# Sheringham Shoal and Dudgeon Offshore Wind Farm Extension Projects

## Final Statement of Common Ground with National Highways (Revision E)

Revision E  
Deadline 8  
July 2023  
Document Reference: 12.22

TITLE  
A47 EASTON  
DRAFT  
ACC47 ACCESS DESIGN  
(SHEET 1 OF 2)

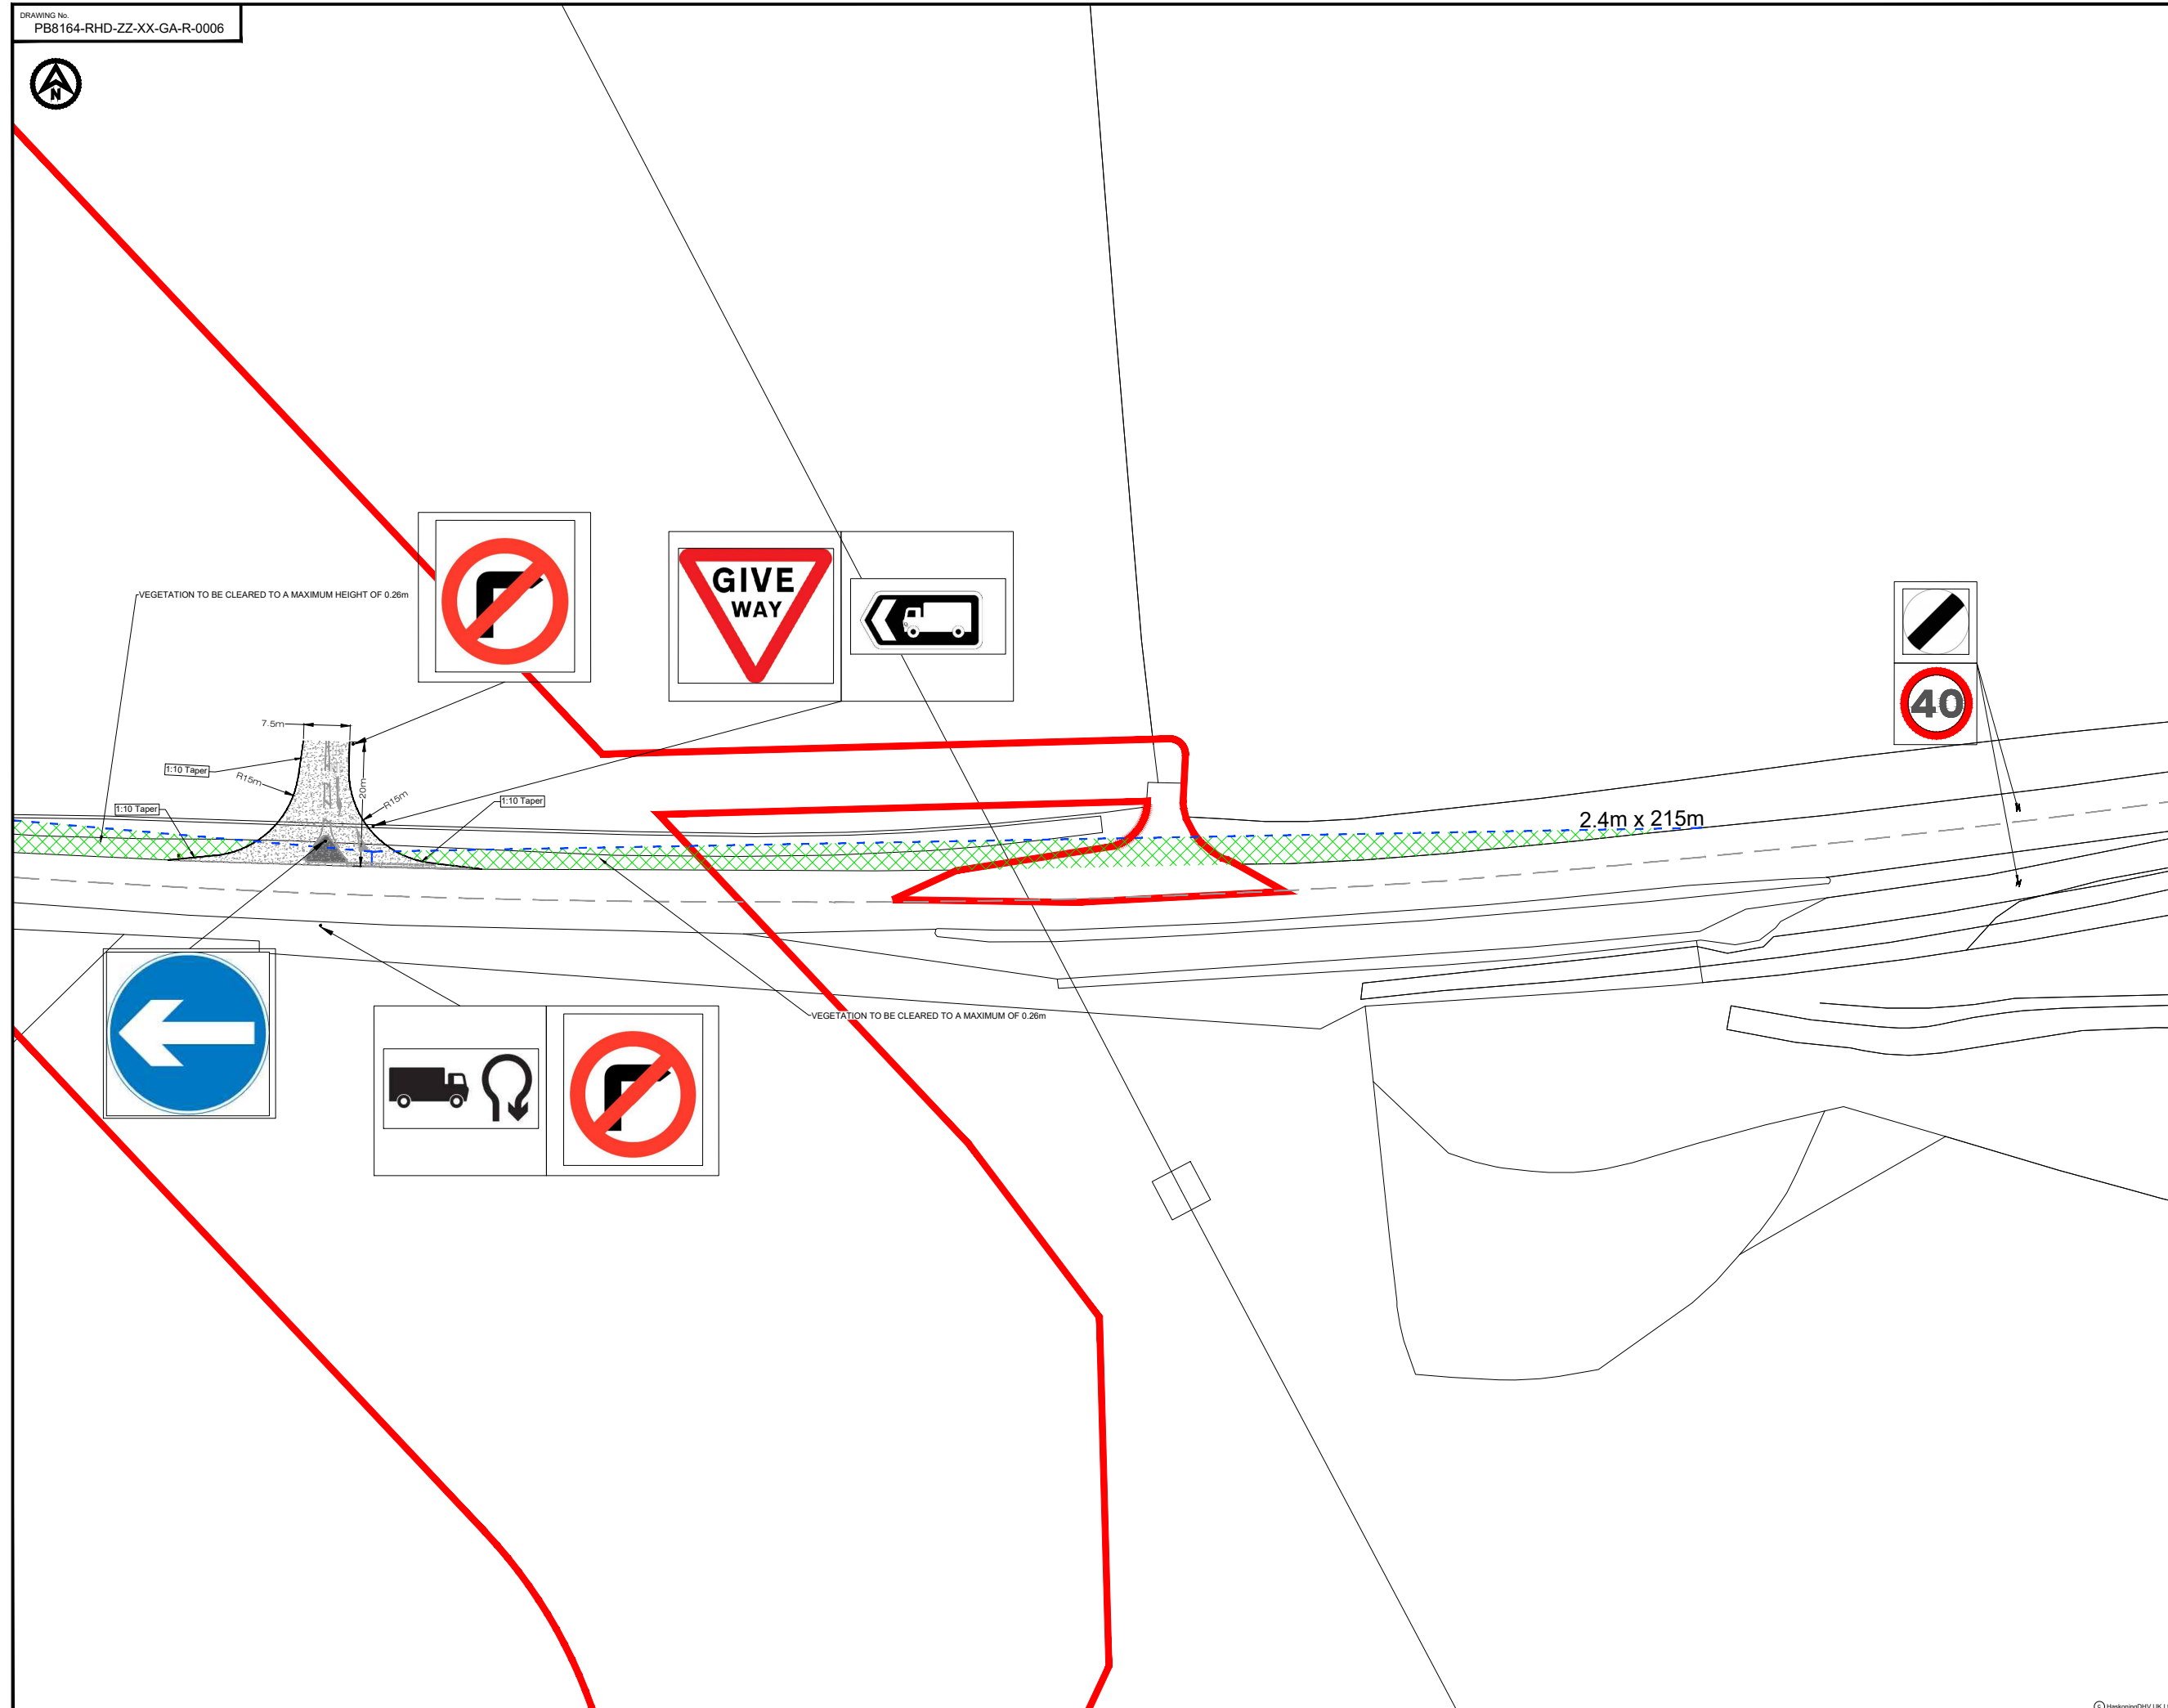
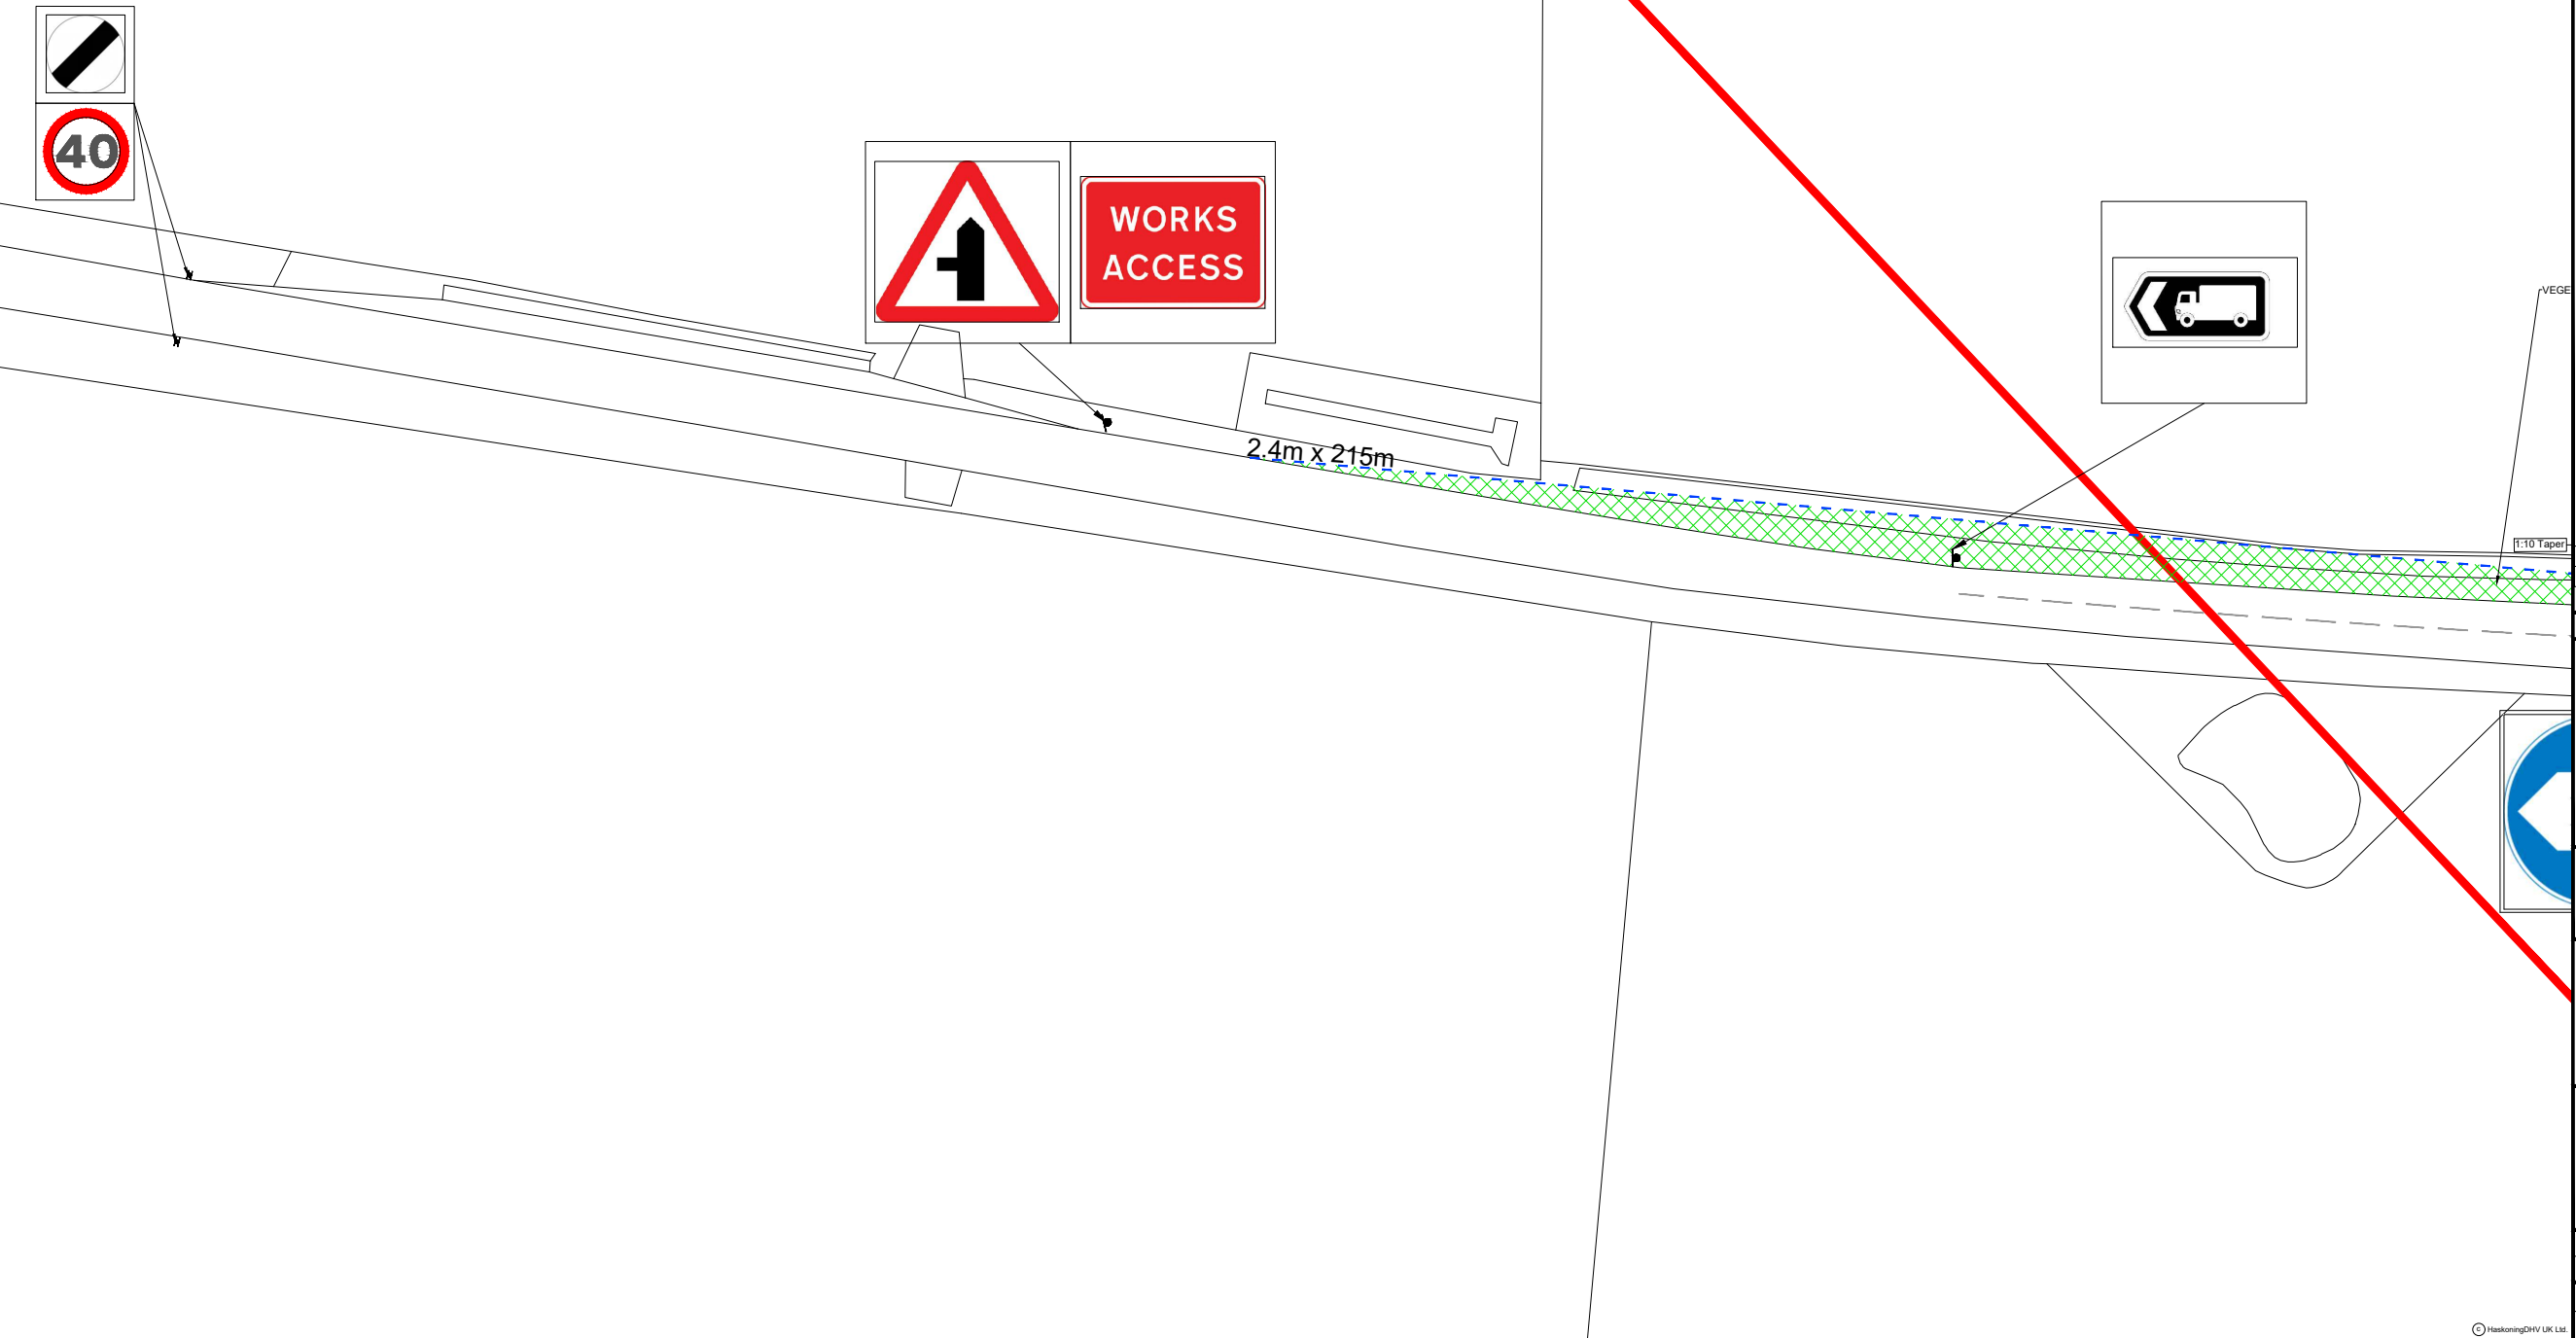
23	The outline design for an access off the A47 is appropriate, as presented in Annex 30 of the Transport Assessment [APP-268 and APP-269]	National Highways agree that the outline design for an access off the A47 (ACC47) is appropriate subject to Stage 1 and 2 Road Safety Audits being carried out post consent. Please note that this access is only usable until the A47 Tuddenham scheme starts construction, or if the A47 Scheme does not go ahead.	<i>Agreed</i>
<b>EIA – Cumulative Impact Assessment (CIA) Conclusions</b>			
24	Cumulative impacts assessment with other windfarms, as presented in Section 24.7 of ES Chapter 24 Traffic and Transport [APP-110], is appropriate based on currently available information and proposed mitigation, impacts are not significant in EIA terms.	National Highways agree that the cumulative impacts assessment with other windfarms, in relation to effects on traffic along the SRN, as presented in Section 24.7 of ES Chapter 24 Traffic and Transport [APP-110], is appropriate based on currently available information and proposed mitigation, impacts are not significant in EIA terms.	<i>Agreed</i>

29	The access concept design for access ACC47 is appropriate and that detailed access designs can be developed and agreed with National Highways prior to the start of construction, secured under Requirement 16 of the draft DCO [AS-009].	National Highways agree that the access concept design for access ACC47 is appropriate, subject to Stage 1 and 2 Road Safety Audits to be carried out post consent, and that detailed designs can be developed and agreed with National Highways	<i>Agreed</i>
